COFFS HARBOUR CITY COUNCIL

Our Ref: 2322082 (PN 2223125 : DA 698/09)

**MP 05-0129, Lakes Estate – 198 Lot Residential Subdivision
Part Lot 95, DP1126227, Lot 10, DP1071628, Lot 1, DP1089778, Lot 2,
DP607602, North Boambee Road and Lakes Drive, North Boambee Valley**

LIST OF ISSUES

**Figure 59** - Area of proposed subdivision to be connected to sewer infrastructure of adjoining land – refer to Appendix GG (Source: RDM 2008)

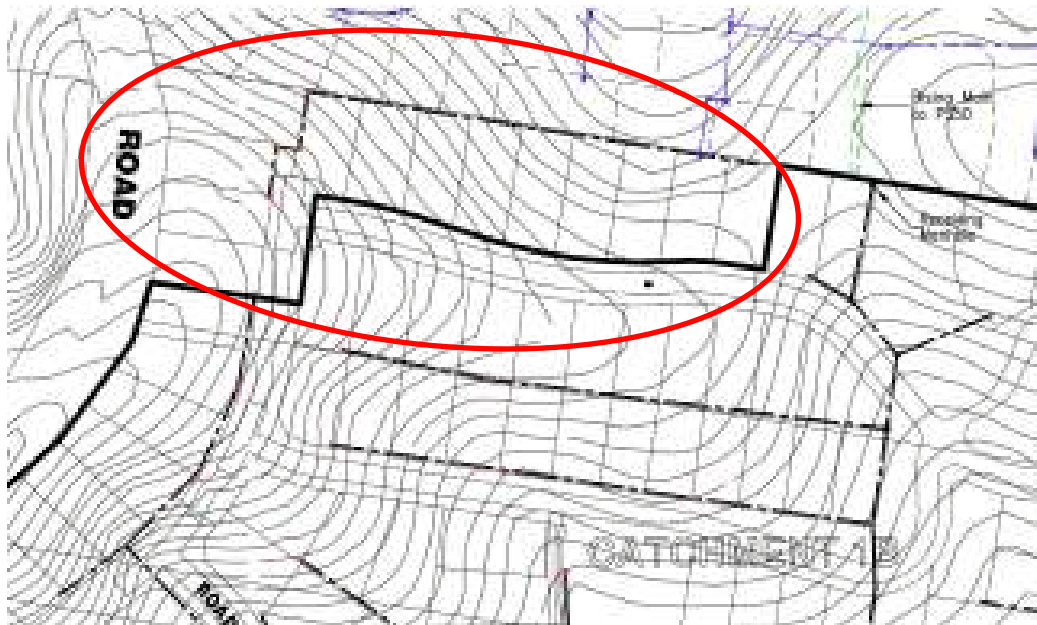
The engineering report suggests that the lots at the north-western end of the site (Lots 87-109 in Stage 2) be served by a new pumping station. An additional SPS is unacceptable to Council. If the area is to be served it must be by gravity to the existing SPS in Highlands Estate. The gravity main would need to run through a vegetated area and the impact of that needs to be assessed.

Figure 62 - Proposed building envelopes – Stage 3 (Source: Astoria Pty Ltd 2009).

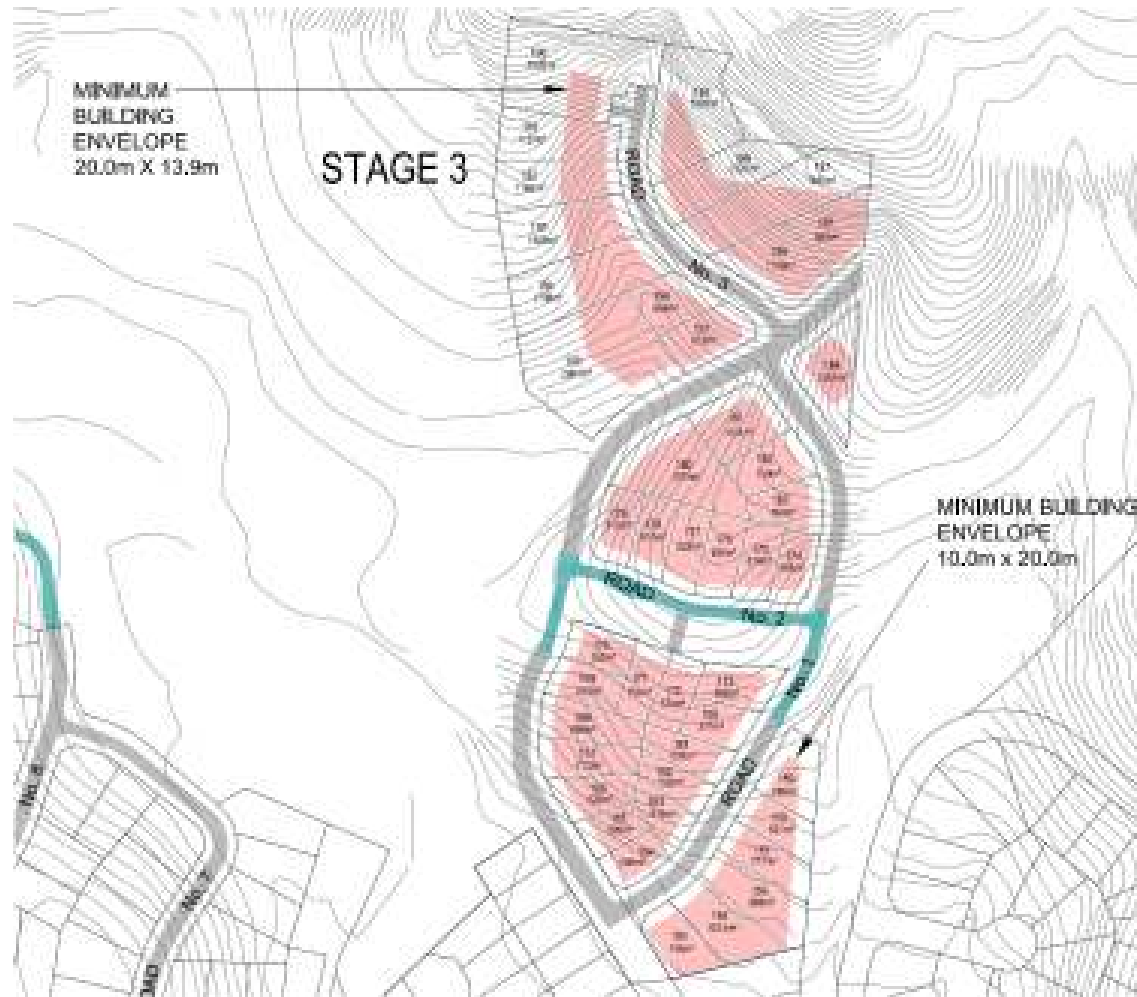
Proposed building envelopes plans (Appendix II) for steep sites (Lots $\geq 20\%$) do not respond to site constraints (access, slope, drainage lines, etc).

Buildings envelopes for lots $\geq 20\%$ should be designed by a geotechnical engineer taking into account the following recommendations:

- Provide a building envelope with an area of not less than 250m² of functional dimensions as part of the subdivision works.
- The building envelope shall not exceed a maximum grade of 20%.
- A concrete access driveway to each lot being installed as part of the subdivision, driveway grade not to exceed 20%.|

Figure 76 - Proposed Option 2 for underground re-routing existing 66KV electricity supply (Source: Resource Design Management 2007)

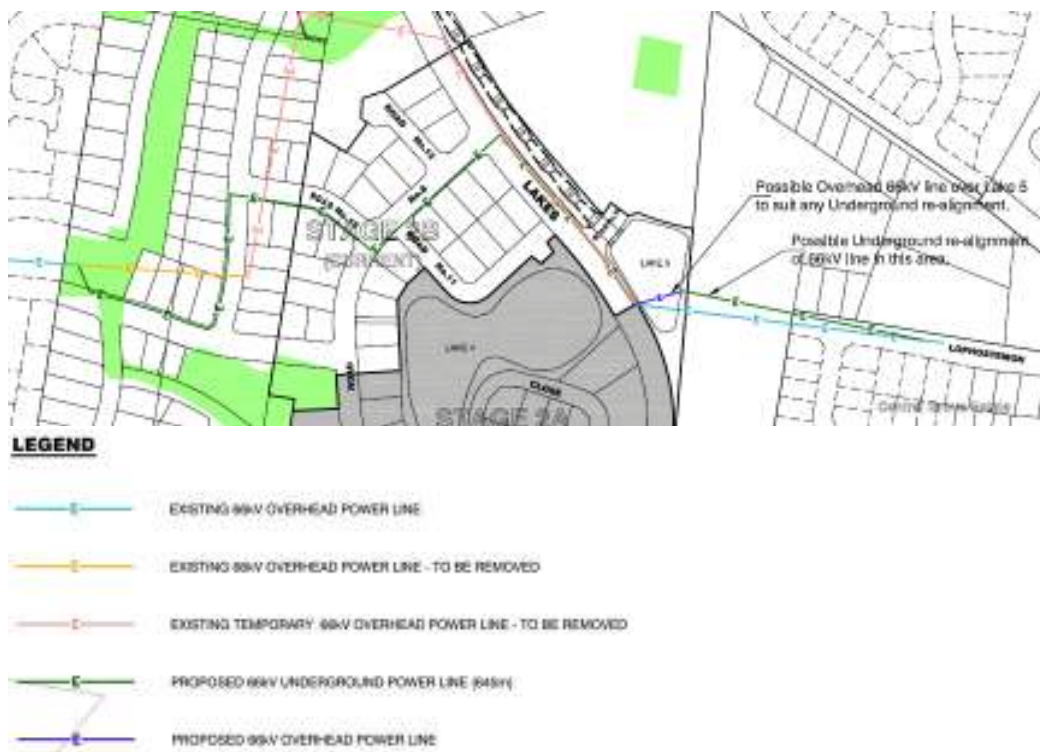
The developers intentions with respect to existing overhead electricity lines and their impact on the subdivision is a relevant consideration.

file name Master Plan.dwg layout name ZONING A3L @ 4000
file location J:\Jobs\6000-6999\6777 - Lakes Drive, Coffs Harbour\Plans\June 2009\
last saved by evan.sawyer © Coomes Consulting Group Pty Ltd
plot date Thu 18 Jun 2009 14:15 Standard Drawing MP A3 L - Version 17 11 08

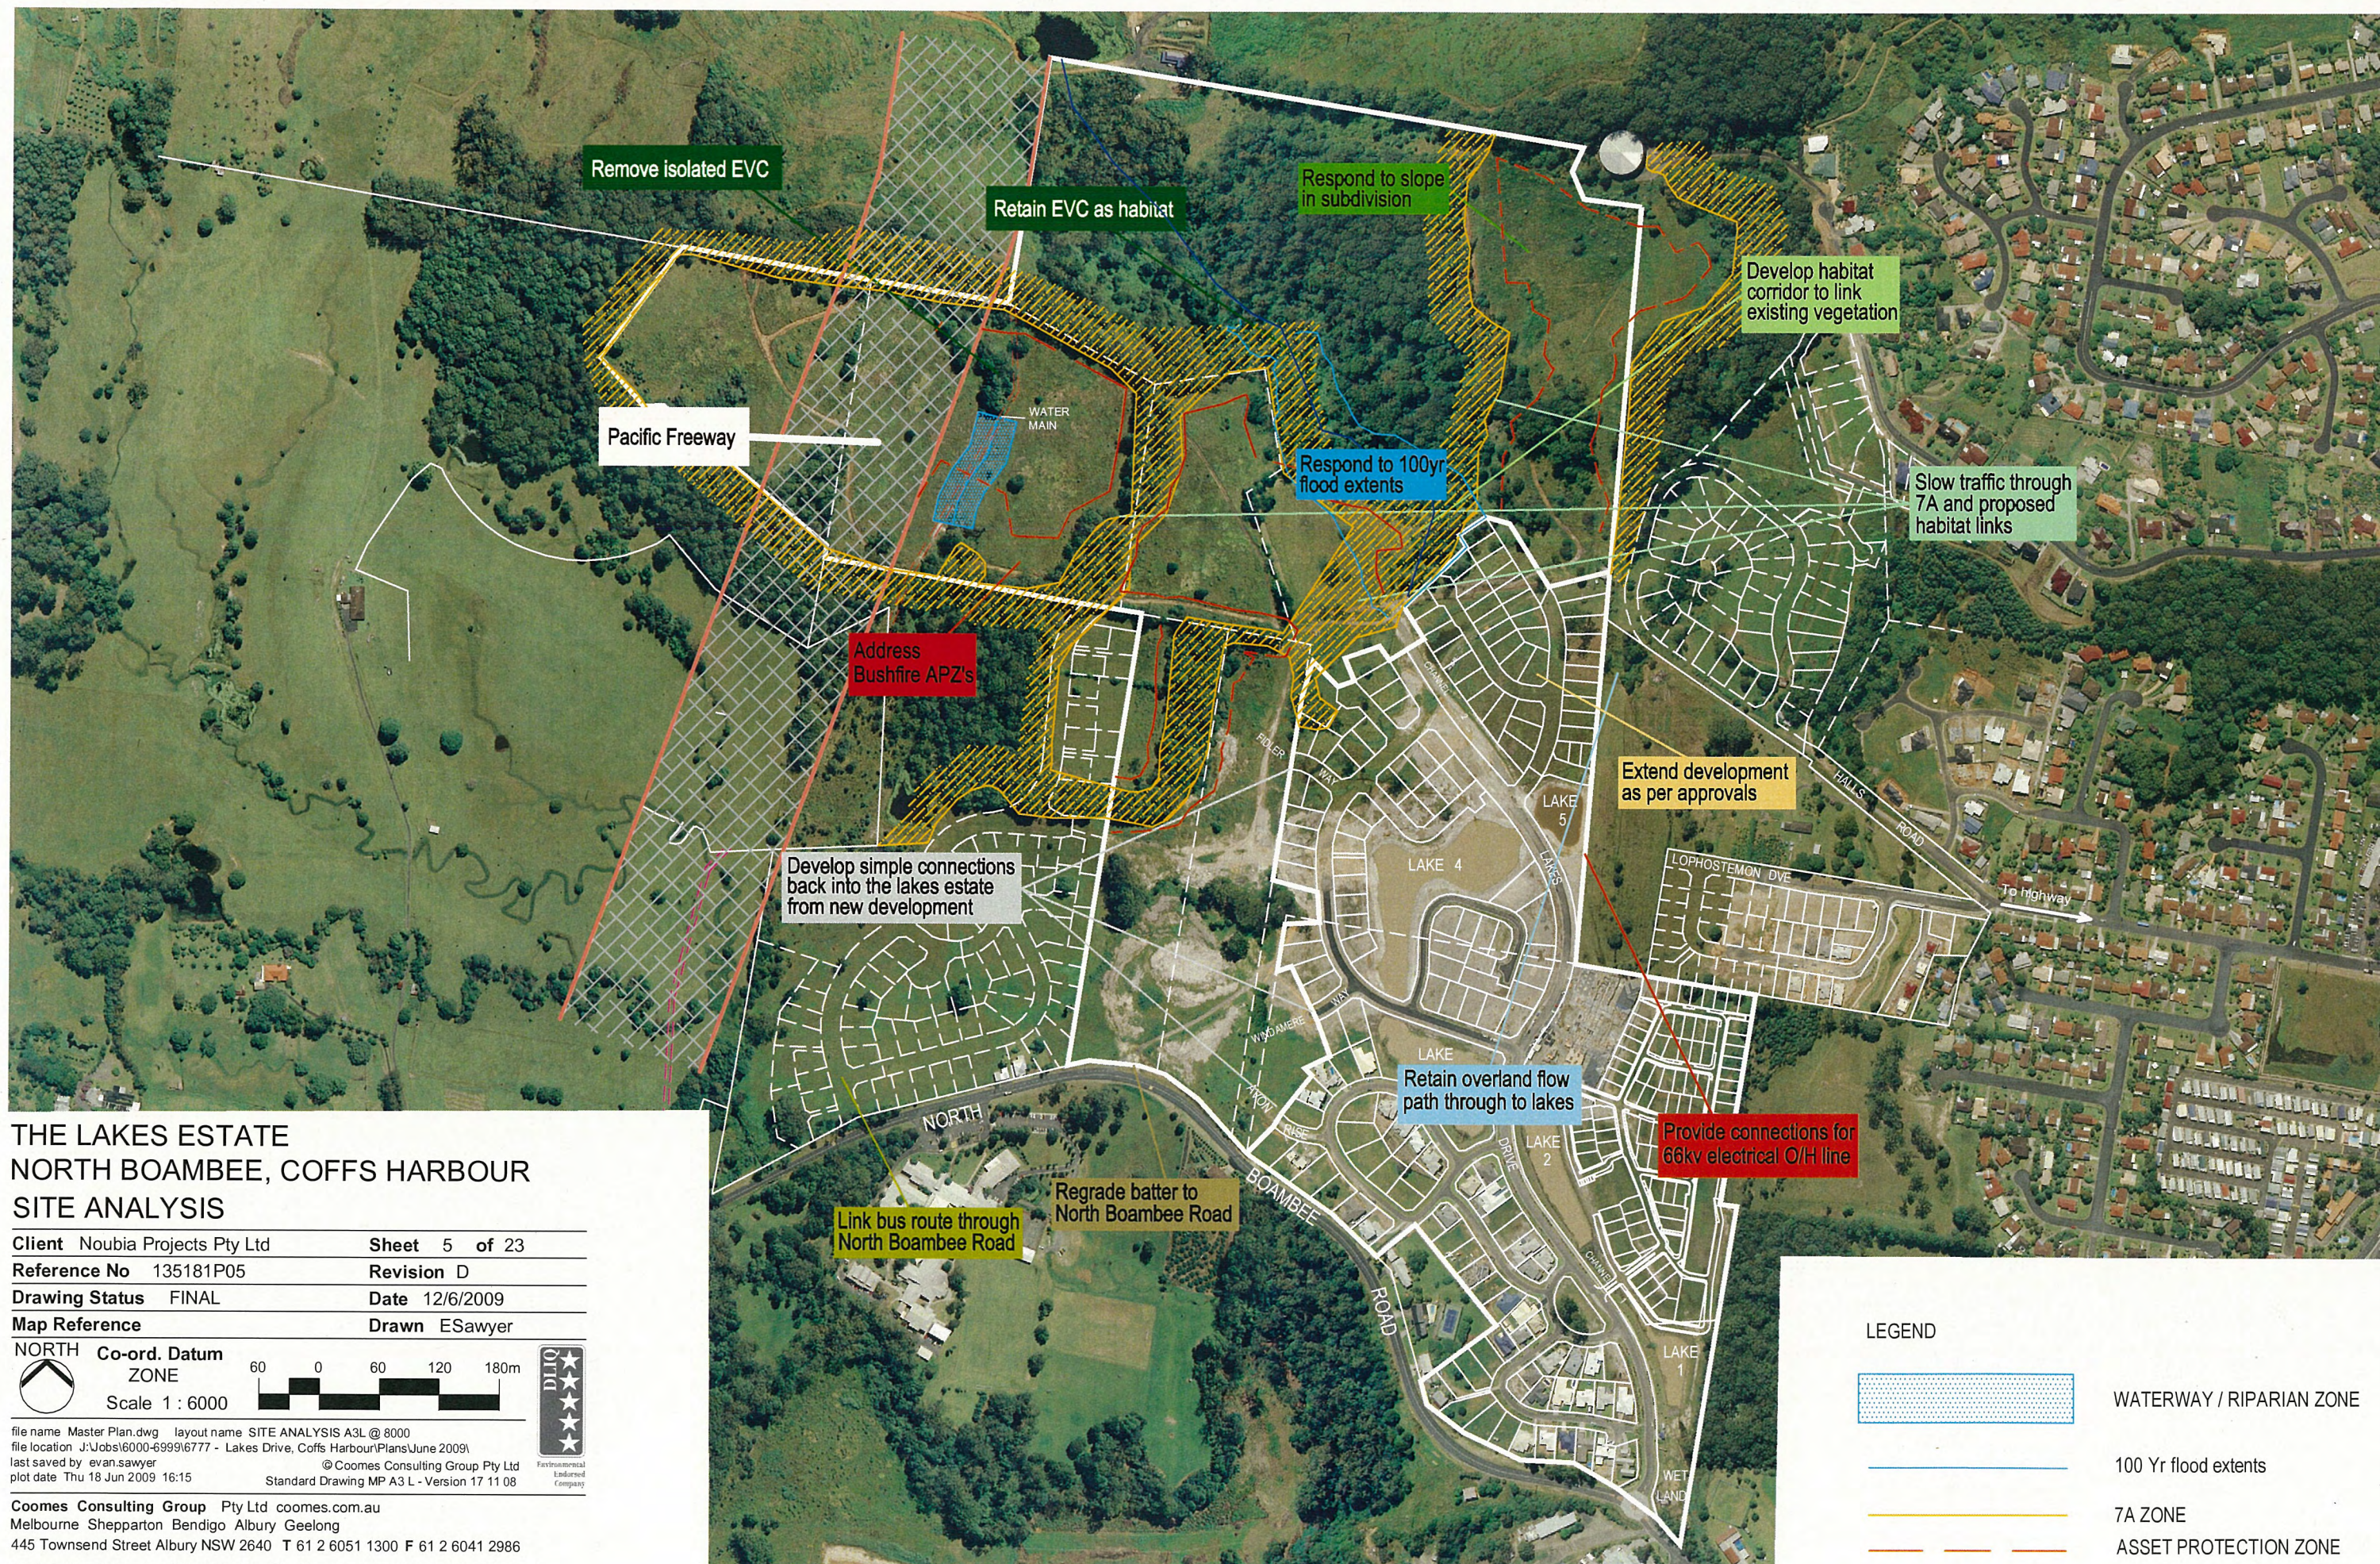
Sheet 4 of 23 in the EA provides an overlay of the proposed subdivision upon the LEP zoning map.

The LEP zoning map (Appendix E – Sheet 4) is incorrect.

The proponent needs to provide a compliant LEP zoning map with the subdivision overlay for evaluation.
